delete title this is a site dev plan for Chicago Fence Supply storage building

Construction Plan 20x40' shed FALCON Fence Supply

05-11-26 PCD File No. PPR2428 M.S.E., INC. PROJECT 61214

V2_ site dev plan.pdf Markup Summary

**SITE PLAN
&
DRAINAGE PLAN**
(Flow Direction)
(Proposed Shed Location)

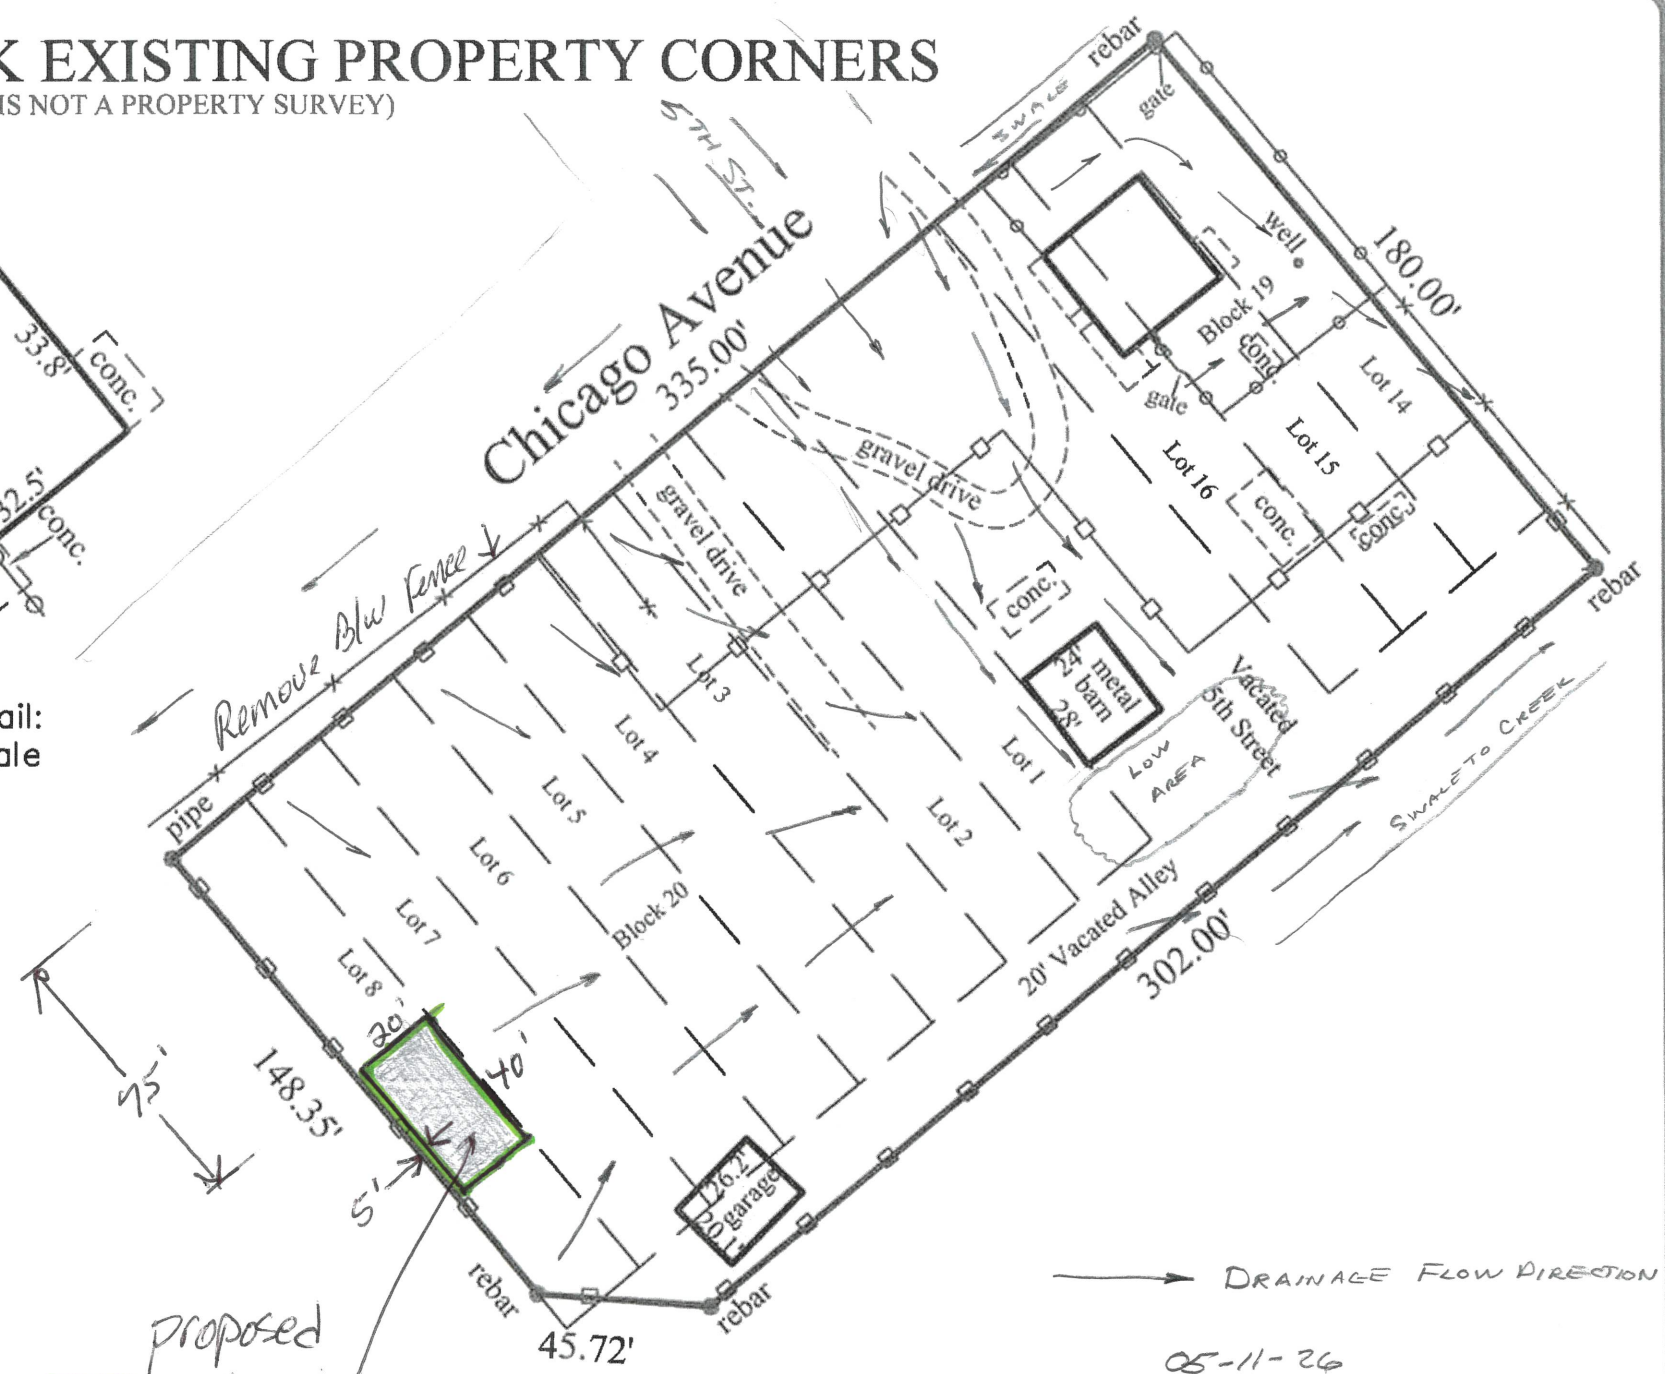
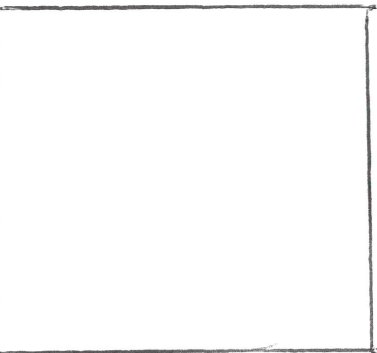
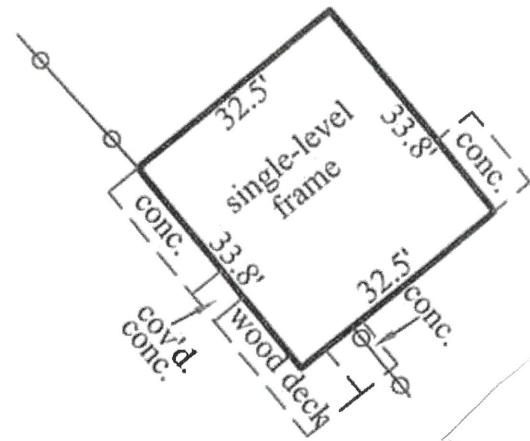
hasnt this all been removed? delete from legend if yes

depict septic area as it can not be driven or parked on.

Provide setback distances from each structure to the property lines. 25' setback adj to RR5

delete this note as new fence is in

Identify existing Single family home and SF

Unresolved: Clarify what is existing and what is proposed. The drainage report states that the only change is to add a 20'x40' shed and the site development plan should confirm that. We need to know the total site disturbance and what are existing vs proposed surfaces/structures.

Depict outside storage area, employee and customer parking. Parking was removed on this round...? If no outside storage is proposed Add a note. If no retail or wholesale customers are to be allowed add a note that no customers so no customer parking needed. Where are company vehicles parked? employees? if none add note.

existing fence 6' or 7' wood, identify with a note so it matched landscape plan?

have all these lot lines been merged into one (remove old lot lines if thats the case?)

Provide setback distances from each structure to the property lines.
25' setback adj to RR5

depict septic area as it can not be driven or parked on.

Depict outside storage area, employee and customer parking. Parking was removed on this round...? If no outside storage is proposed Add a note. If no retail or wholesale customers are to be allowed add a note that no customers so no customer parking needed. Where are company vehicles parked? employees? if none add note.

Identify existing Single family home and SF

existing fence 6' or 7' wood, identify with a note so it matched landscape plan ?

delete this note as new fence is in

for business verses sf home

hasnt this all been removed? delete from legend if yes

Include label:
Private Access

Unresolved: Clarify what is existing and what is proposed. The drainage report states that the only change is to add a 20'x40' shed and the site development plan should confirm that. We need to know the total site disturbance and what are existing vs proposed surfaces/structures.
